Date: 27th January 2017
Our Ref: 14/351

Re: MP07_0026 – Epiq Estate Lennox Head (formerly Pacific Pines)

Newton Denny Chapelle (NDC) has been instructed by Clarence Property Pty Ltd to respond to the public and government agency submissions received for the proposed Modification to M007_0026 for Epiq Lennox.

EPIQ LENNOX HEAD
ILLUSTRATION C1 -
CONCEPT PLAN

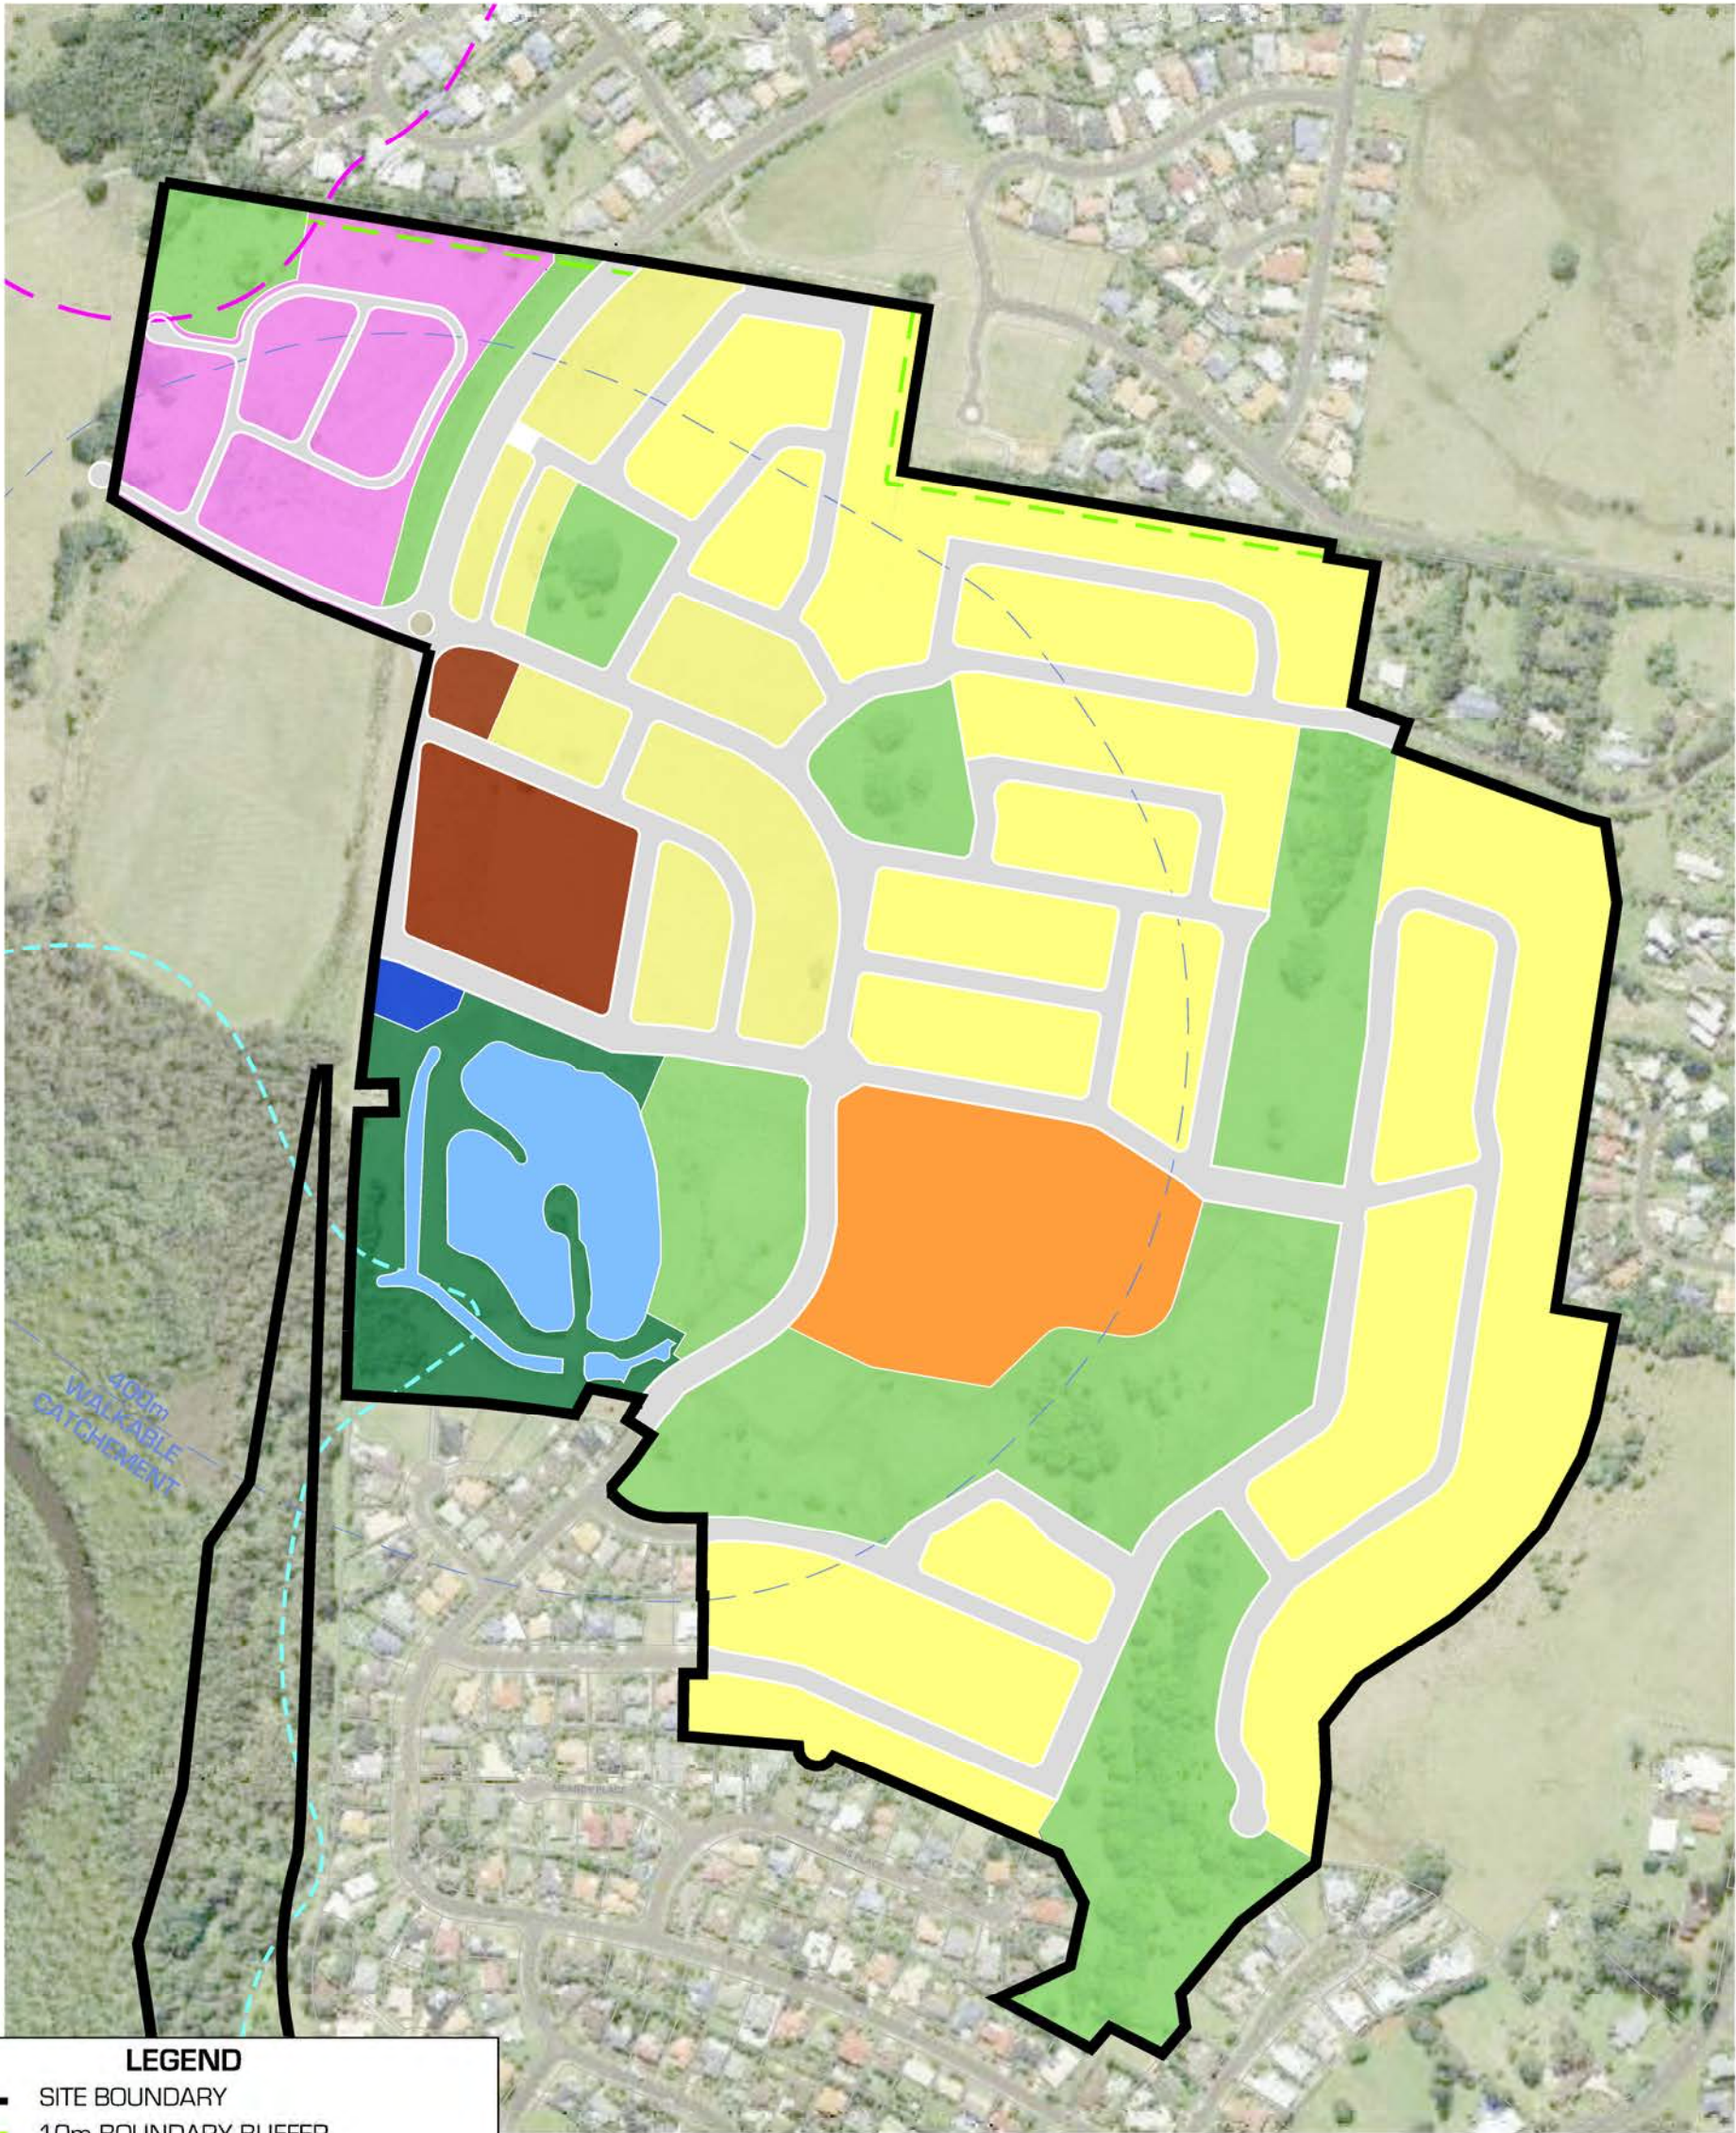
Government Agency	Agency Comments	Proponent Response
Department of Environment & Heritage	<ul style="list-style-type: none"> • The maps included in Mod 5 to include the Littoral Rainforest and associated buffer. • Any future DA should have regard to the flood impacts upon the development. 	<ul style="list-style-type: none"> • All plans lodged with Mod 5 (specifically C11), which included the Littoral Rainforest & Arrow Head vine have been updated to include the prescribed 10m buffer. The full plan set is provided within Attachment 1 of this letter. • The assessment completed for the Concept Plan approval considered flood impacts. Through the assessment a condition of approval was included by the Department of Planning & Environment requiring that the finished floor level of buildings on Super Lot 6 be RL 2.65m AHD. • The Department considered that the filling of the site and the construction of the future buildings at a minimum level of RL 2.65m AHD will provide the development with sufficient immunity against both local and global flood events. In the result of a

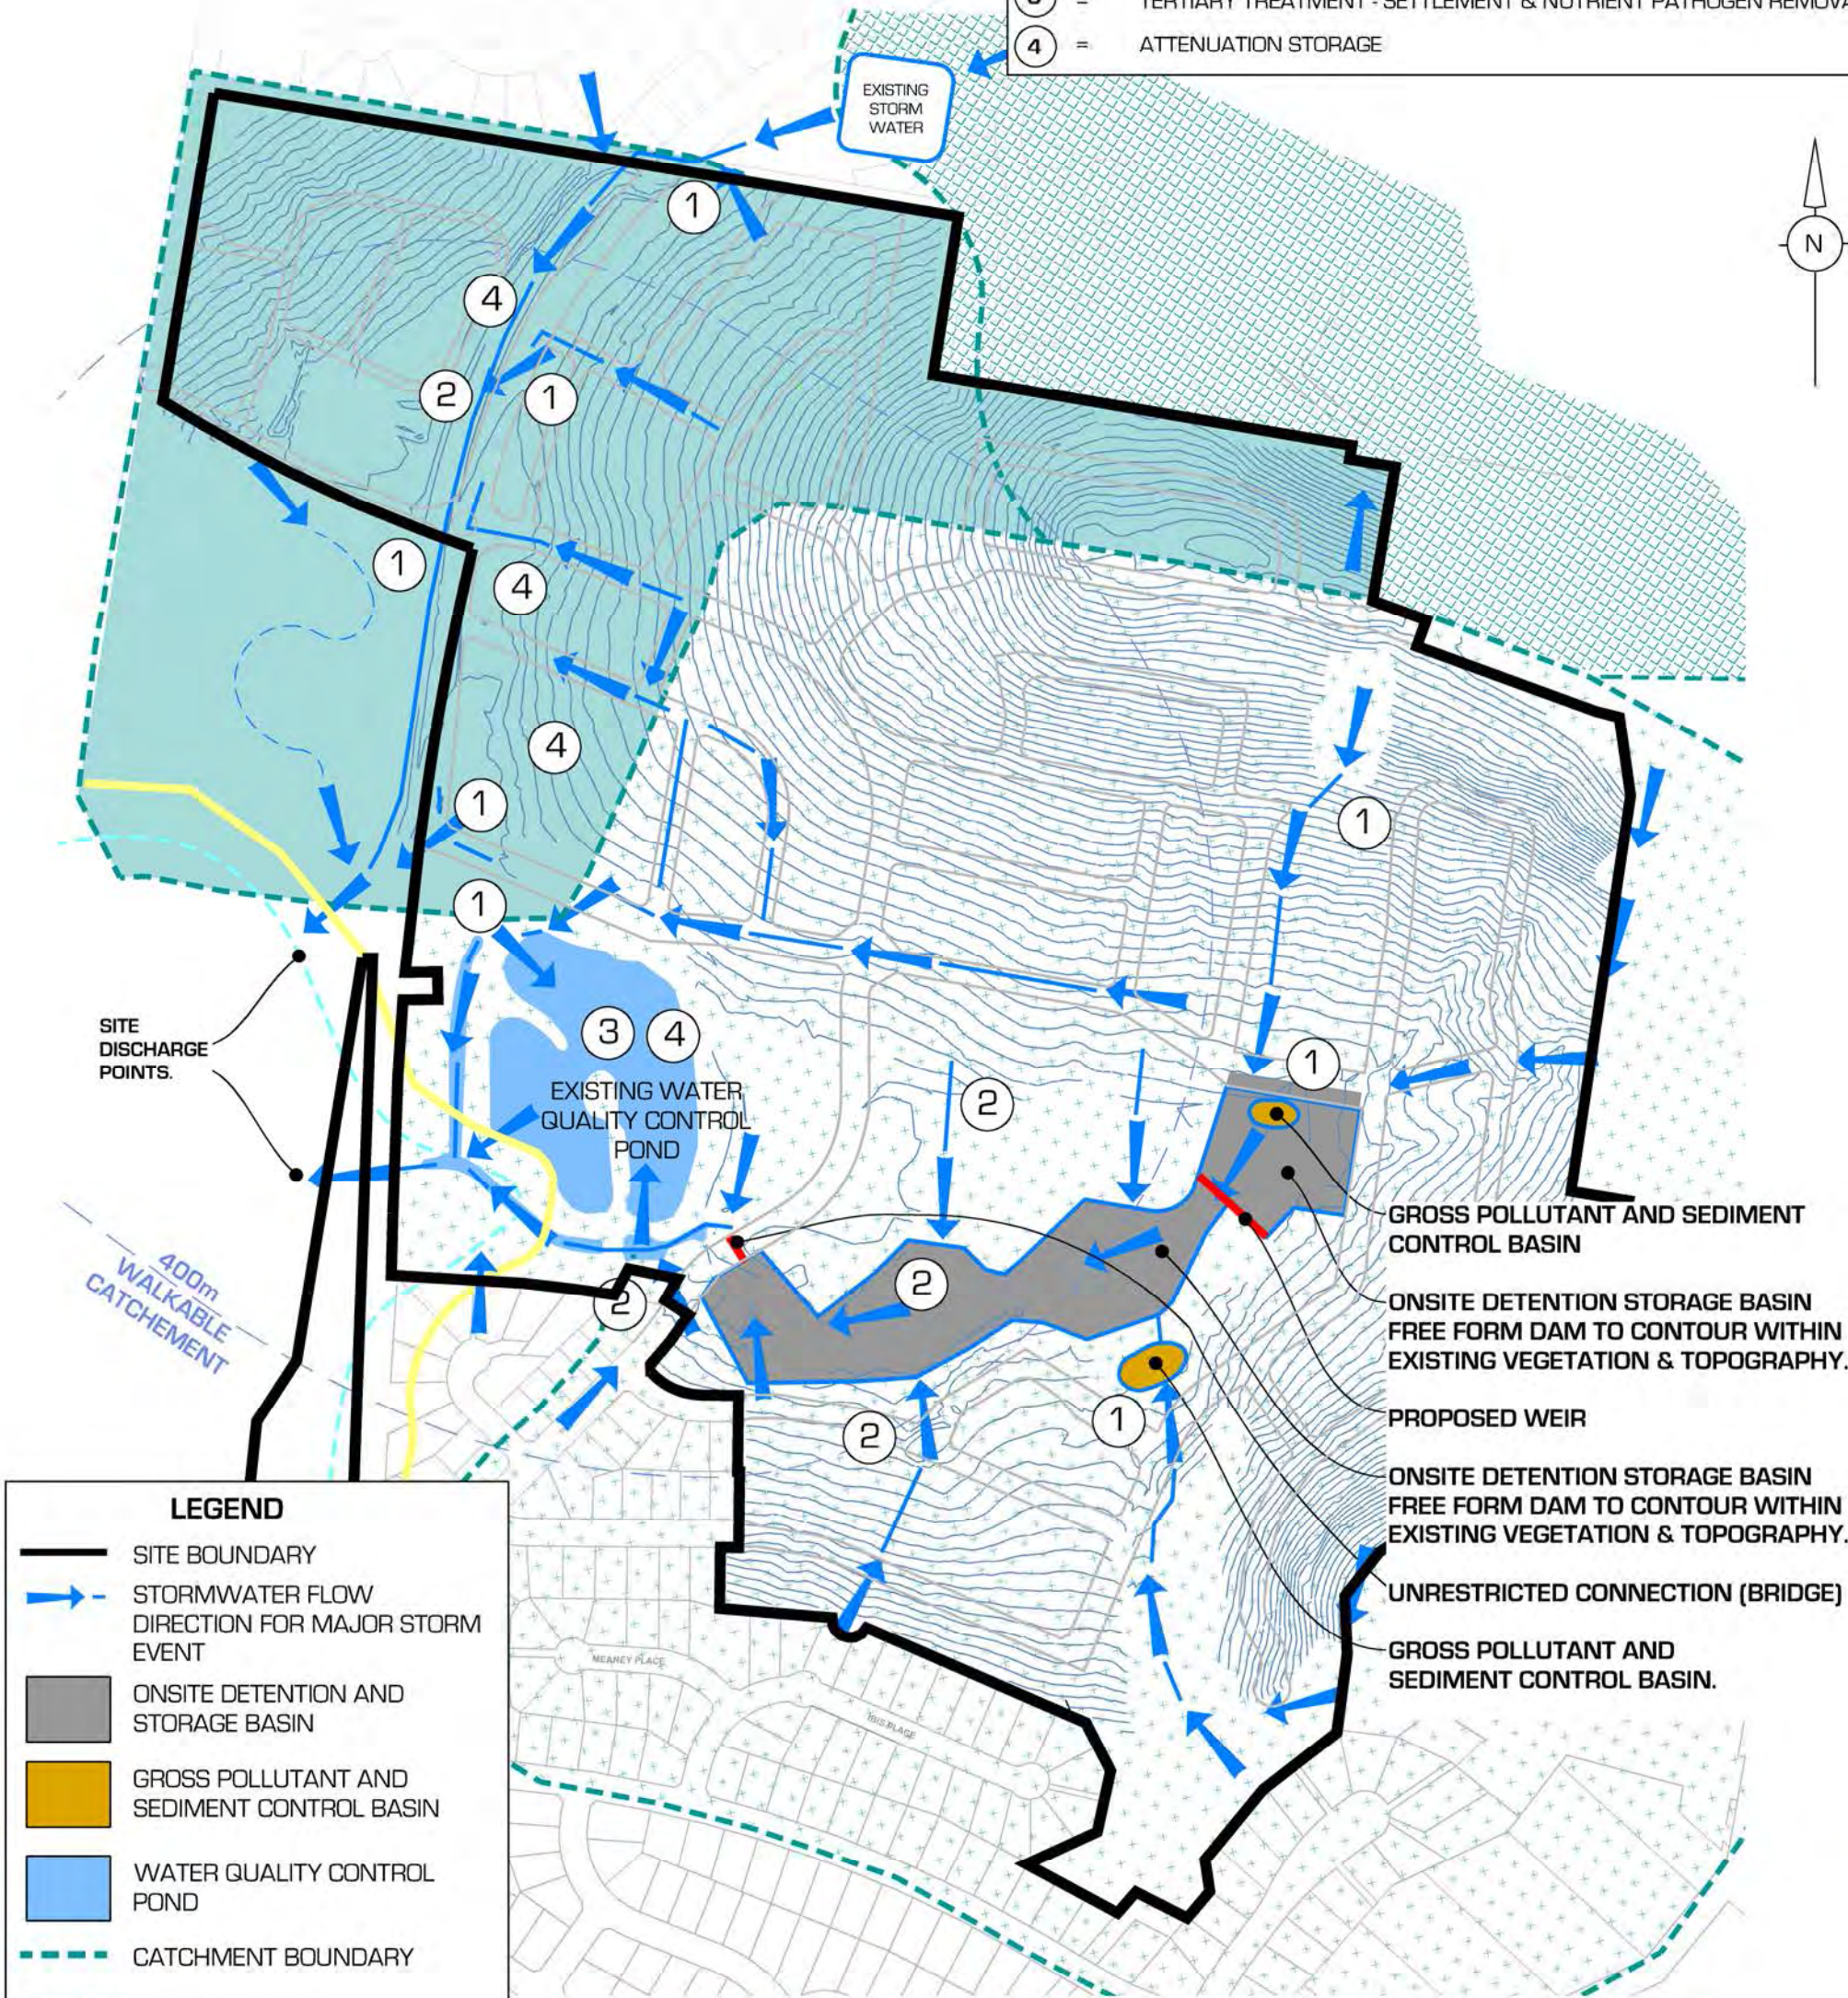
- TIA identifies the need to upgrade the Henderson Lane and Montwood Drive intersections with North Creek Road. Both intersections are close to downstream junctions. After reviewing the traffic generation calculations, the design of these intersections should be further investigated to ensure that sufficient separation of intersections treatments can be
- The configuration of these intersections is as per the previously approved TIA completed by Cardno for the local road network (Henderson Lane and Montwood Drive) at capacity, ie 7,456vpd. The revised TIA does not propose to exceed the traffic numbers nominated by Cardno. The layout of these intersections have been designed with regard to the Austroads Specifications

achieved to provide the required vehicle storage, deceleration and taper lengths for traffic turning from North Creek Road.	
Ballina Shire Council	<p>Retail Floor Extension</p> <p>Street Classification</p> <p>Road Network</p>	<p>Reference is to be made to the Location IQ memo (see Attachment 2) which addresses Council's key issue associated with the trade area adopted within Location IQ's EIA to that contained within Ballina Shire Council's Lennox Head Community Aspirations Strategic Plan.</p> <p>When applying the trade area as defined by Council's Strategic Plan, Location IQ note the population is currently 6,940 and increases to some 9,840 by 2018. On this basis, the demand for a supermarket as proposed is justified utilising the neighbourhood trade area under Council's Lennox Head Community Aspirations Strategic Plan. On the basis of the population growth and the scale of retail centre proposed, Location IQ reaffirm the development is appropriate to serve the convenience needs of the local catchment.</p> <p>The EIA lodged with the Section 75W application, identified the proposed Epiq Lennox centre would not modify the retail hierarchy for both the Lennox CBD and the broader Ballina Town Centre.</p> <p>The Lennox Village centre is generally focussed on food and services, which aligns to the coastal location. Accordingly, the Lennox Head village centre has evolved to be a destination for both the broader local and tourist markets. Location IQ submit the village centre will operate at a different level in the retail hierarchy to the proposed convenience retail facilities at Epiq Lennox, hence thereby not competing against each other nor dismantling the village centre as the primary trade area.</p> <p>The location of the centre promotes connectivity for local residents through its links to existing and proposed pedestrian networks. To this end, the convenience function serves the primary residential growth area of Lennox Head (Epiq Lennox, Meadows Estate & Henderson Farm) which are all within walking distance to the proposed centre.</p> <p>The Movement Network Illustration C6 has been updated to reflect the street classifications as per the Northern Rivers Local government classifications. The reference to the SMEC street classifications has been removed as requested</p> <p>This condition is in accordance with the Ballina Shire Requirements and the Preliminary Road Network Sketch prepared by Newton Denny Chapelle. NDC is happy with this condition</p>
